RE: **Old Dominion Freight Line - 330 Airport Road NW  
Grading & Drainage Plan and Drainage Report**

File **K10-D008A**  
PE Stamp: 3/19/13

Based upon the information provided in your submittal received 3/19/13, the above referenced plan cannot be approved for Grading Permit or Building Permit until the following issues are addressed:

**OUTLET STRUCTURE DETAIL**  
 NTS

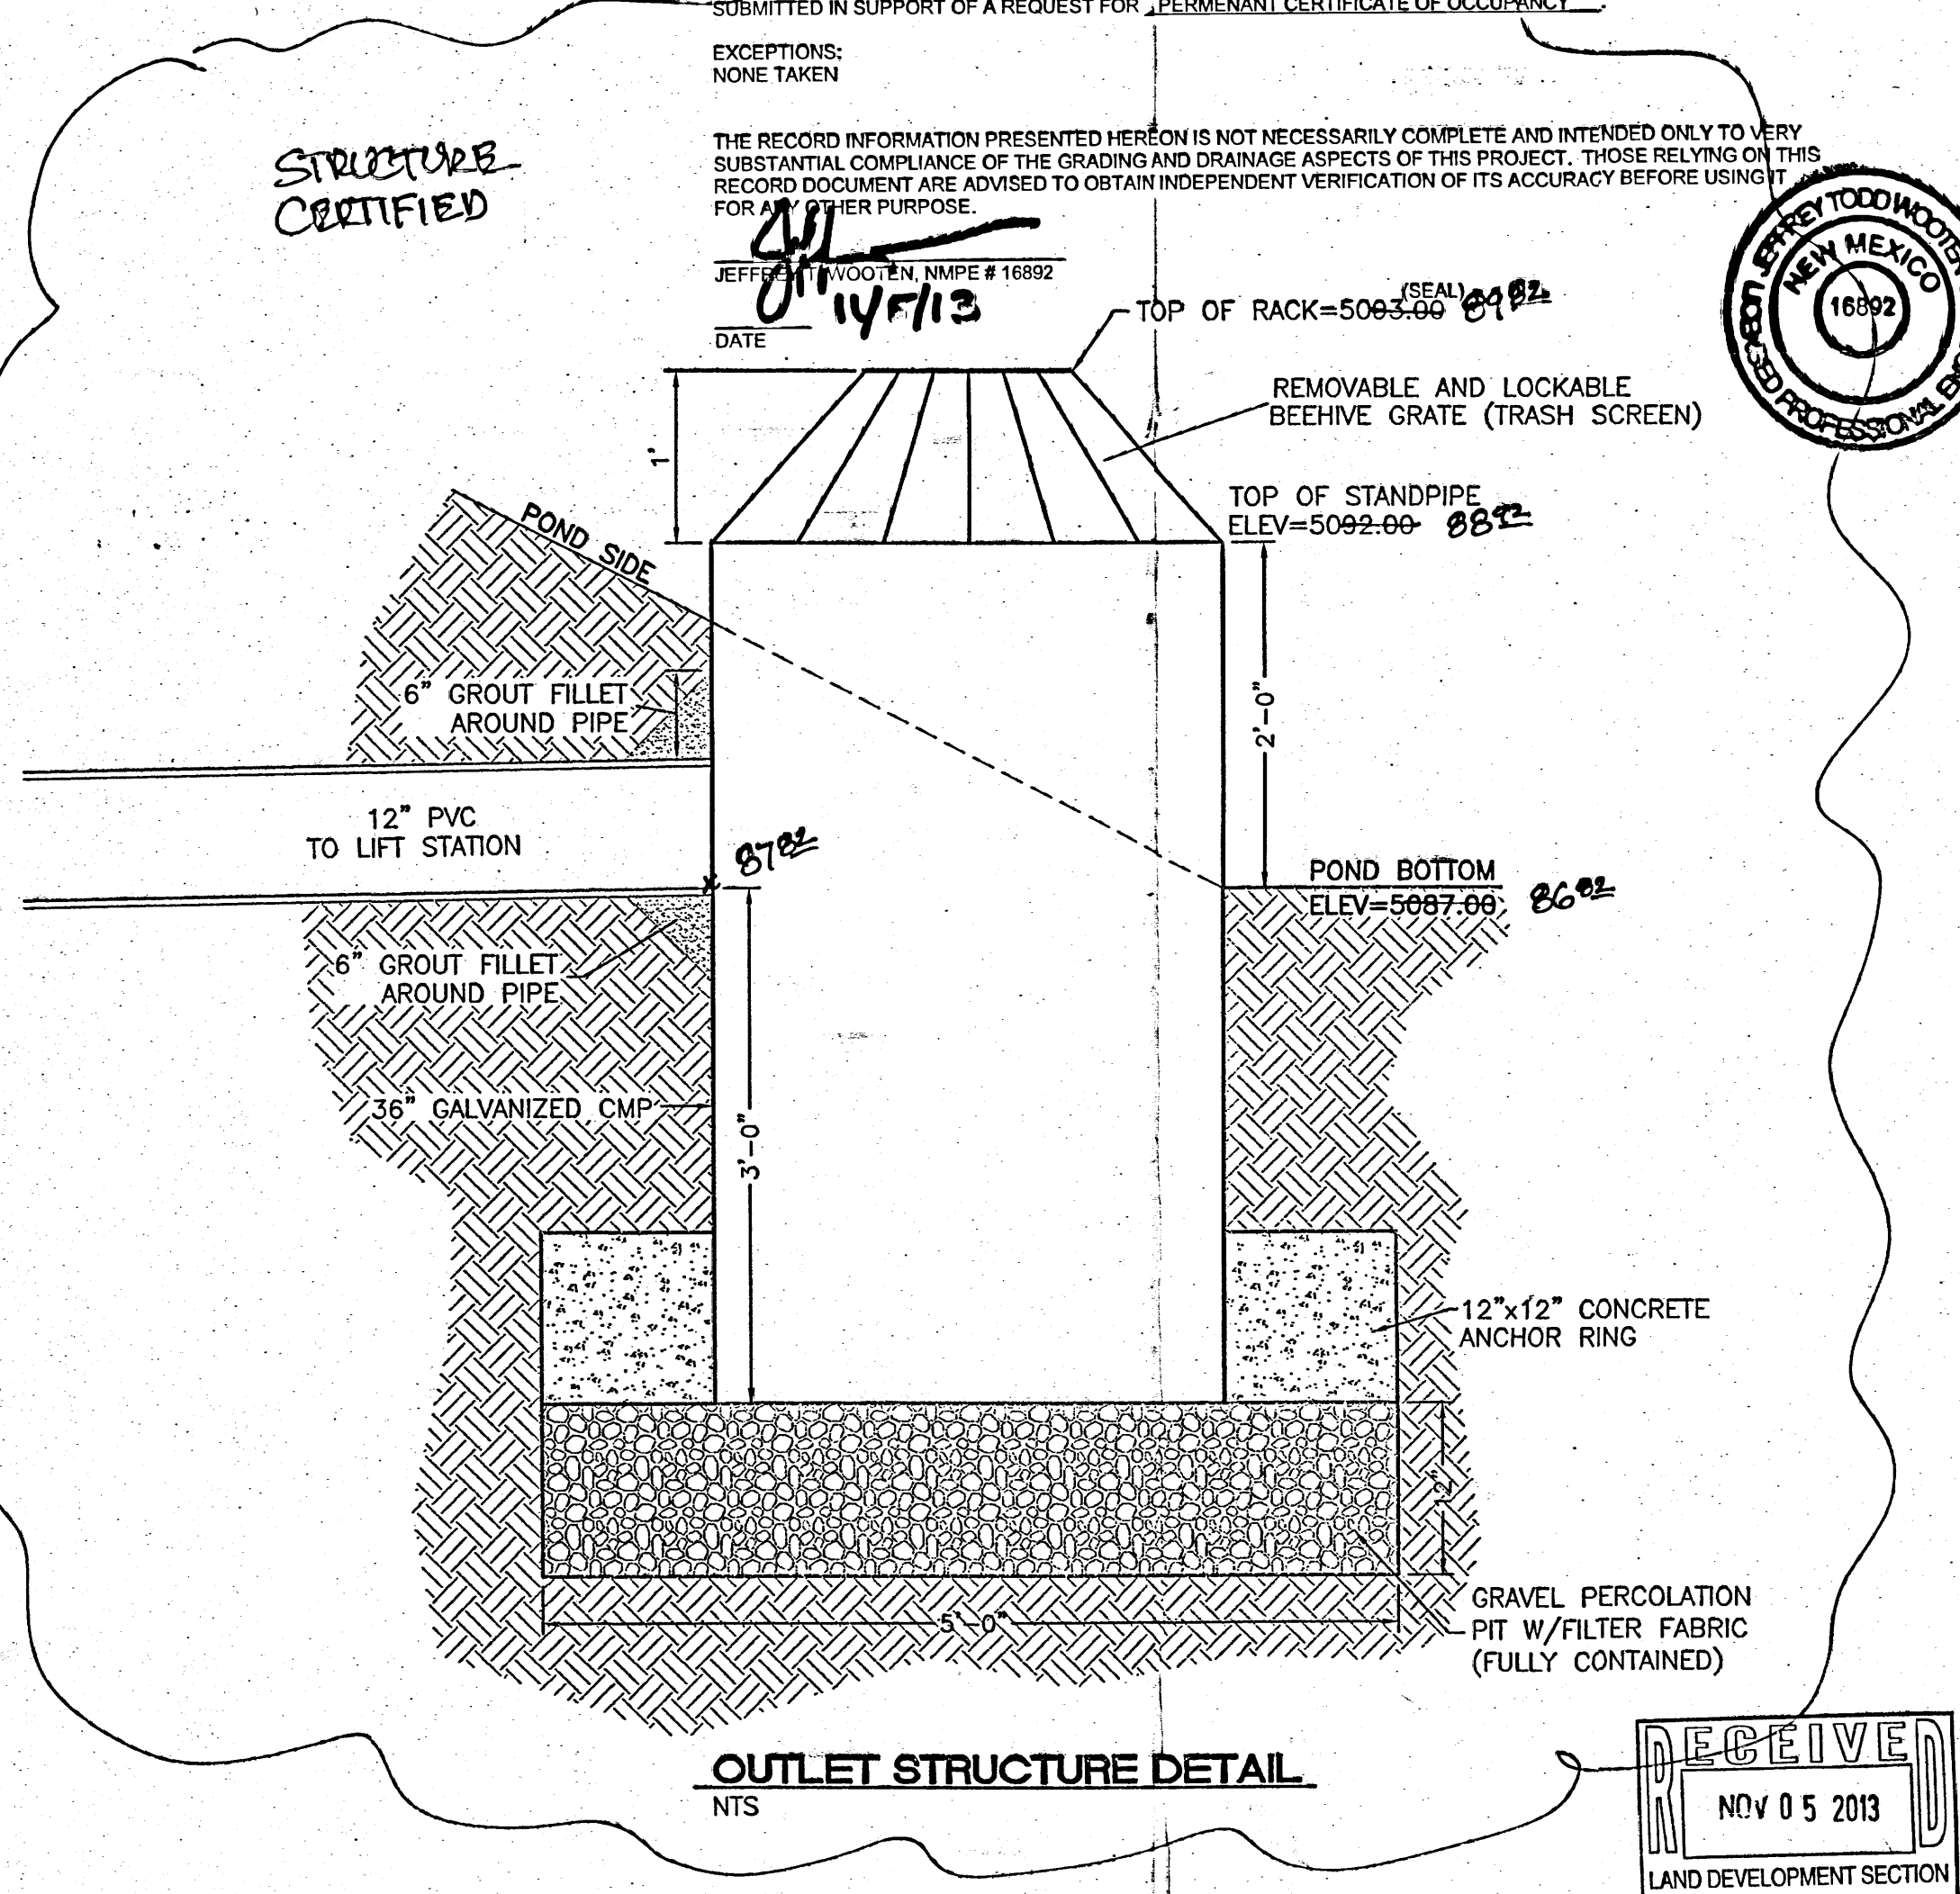
3. On sheet C5, the outlet structure inverts differ from those shown on the Grading Plan. Also, it does not show the 2" diameter, low flow ports that were shown on the previous submittal. Is the pond intended to retain two feet of water?

Sheet Name:  
GRADING AND DRAINAGE PLAN

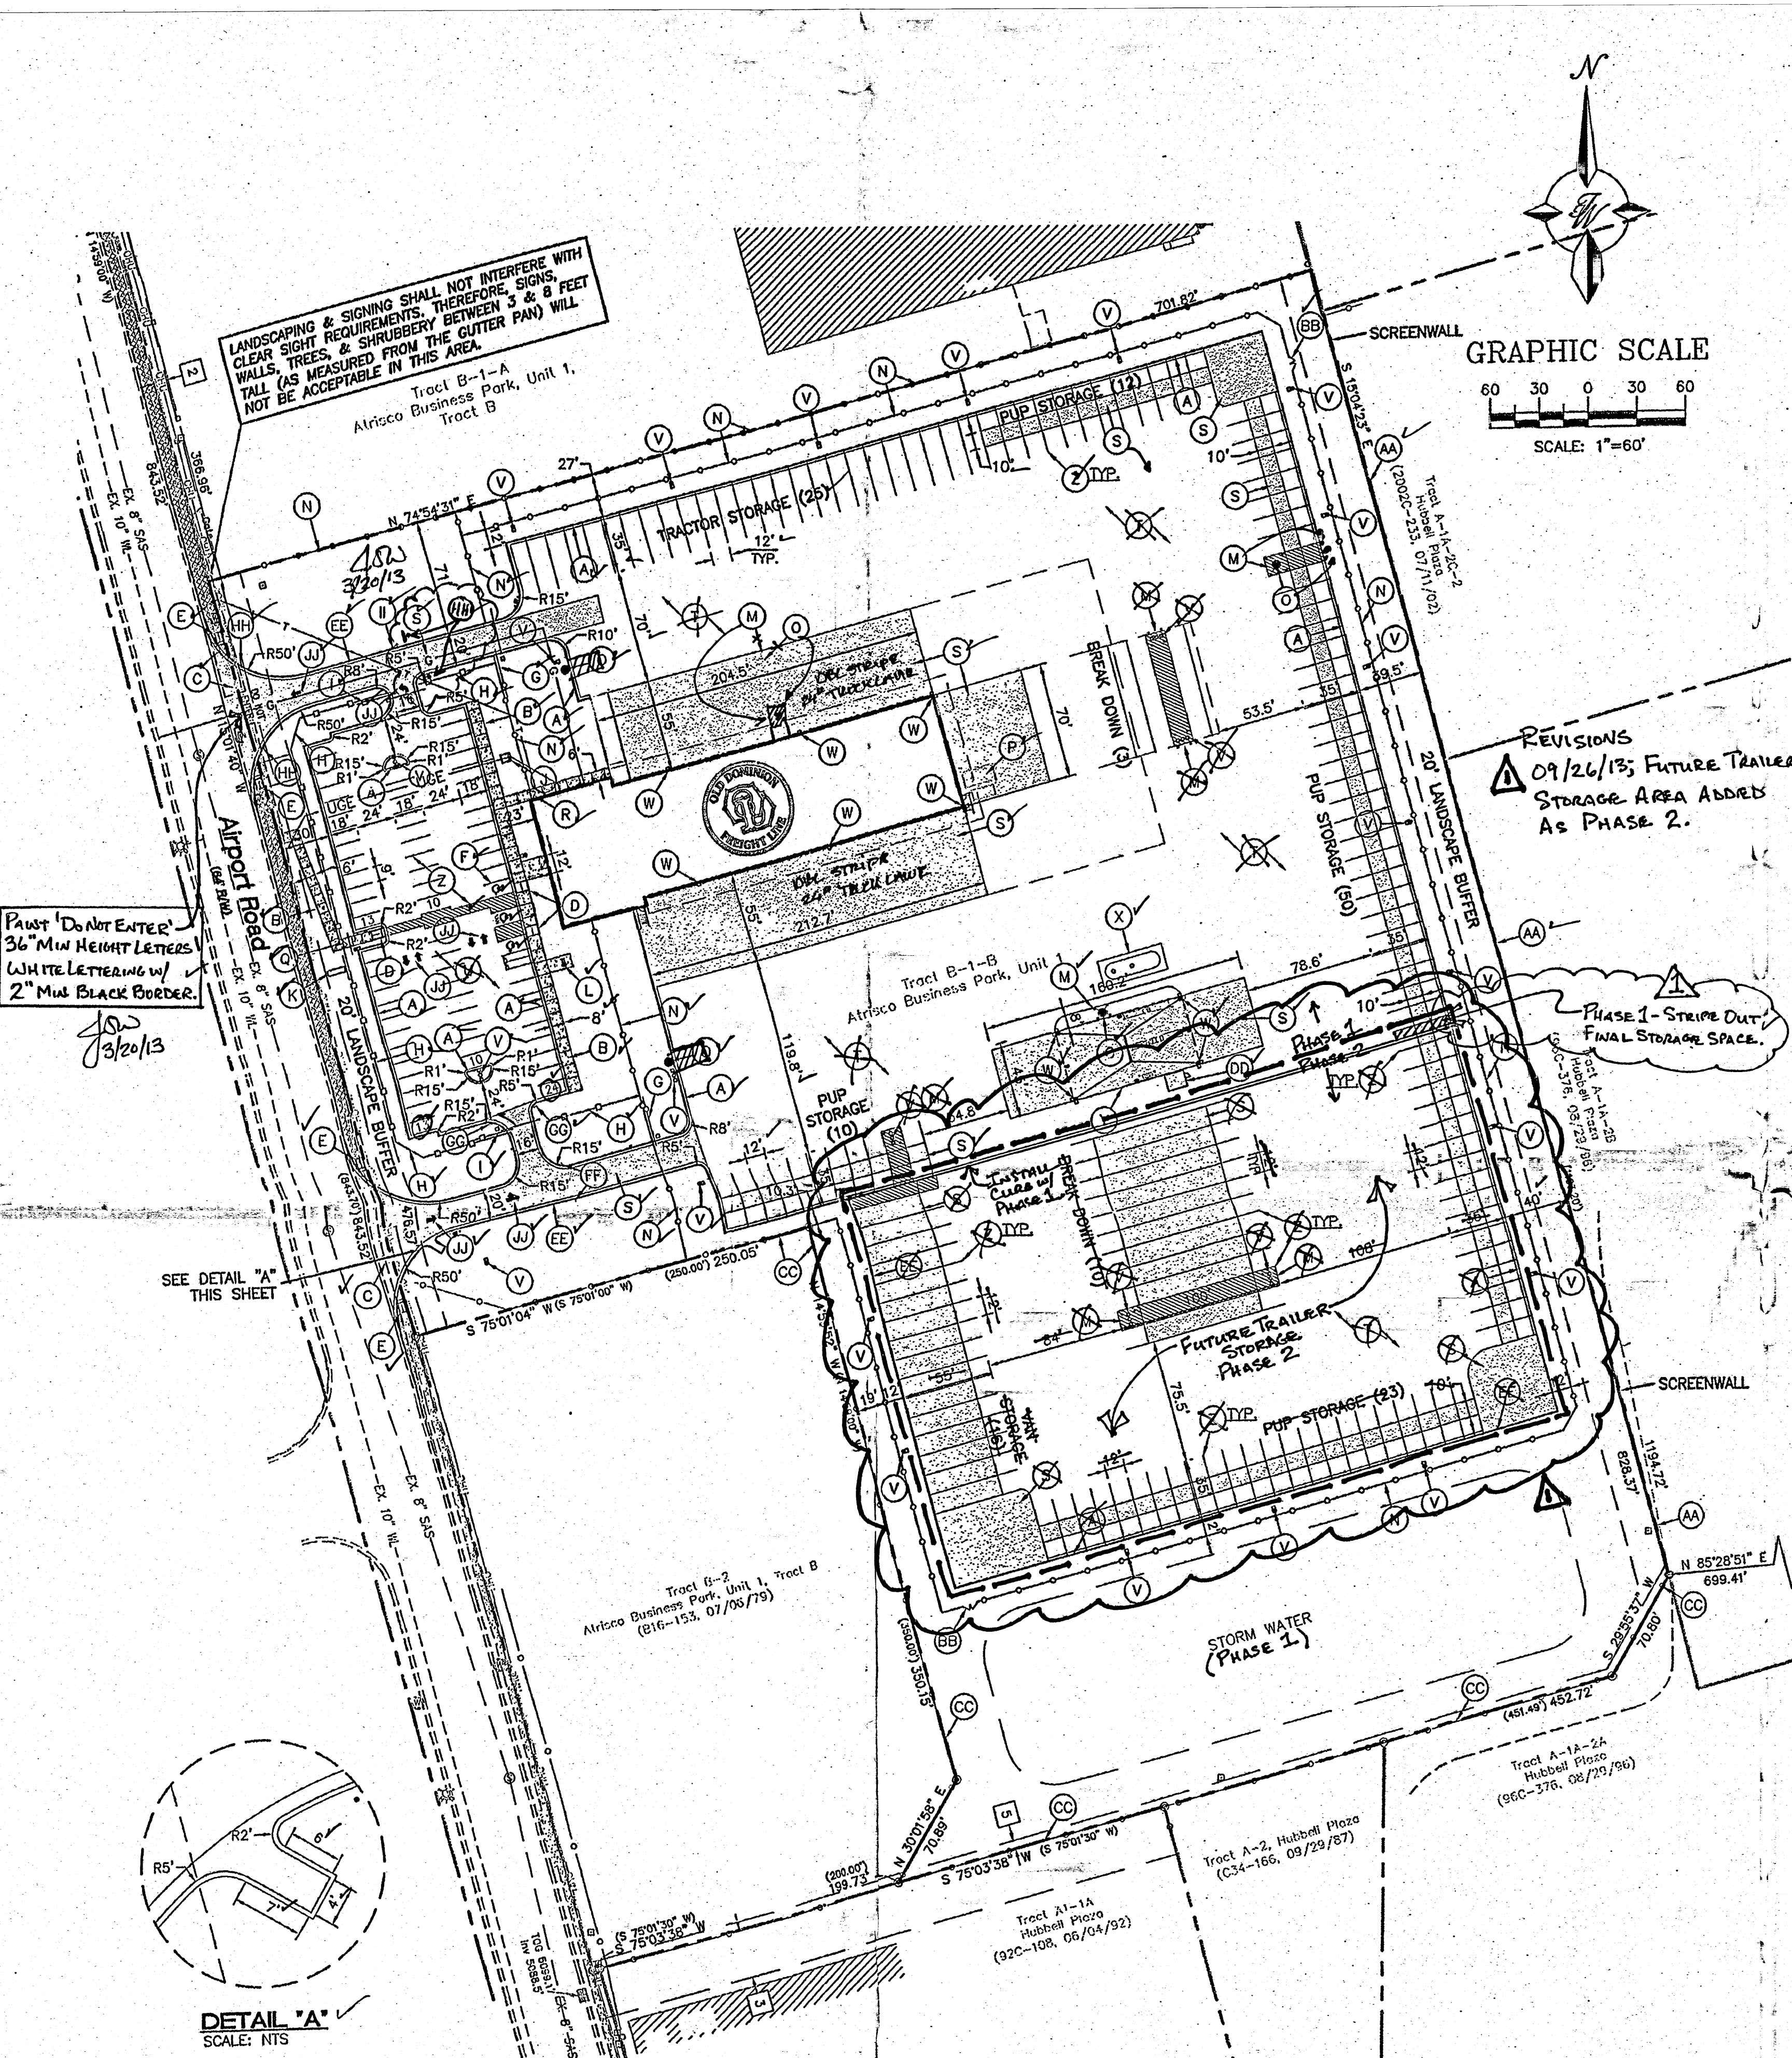
1. Show the limits of the existing Special Flood Hazard Area (BFE = 5097) on the plan.
2. Include the stormwater pump model, size, and discharge rate on the plan, and thus include the As-Built pump information on the future, drainage Certification plan.

4. The plan and report do not include any channel section or capacity calculations for the North and East perimeter channels. The landscape plan shows numerous trees along the perimeter channel. Confirm that channel capacity is adequate for design flows.

5. Please include pond lining and channel mulch specs on the G&D, rather than just referring to the landscape plan. If landscaping requirements change, they must be reviewed and changed in the G&D.
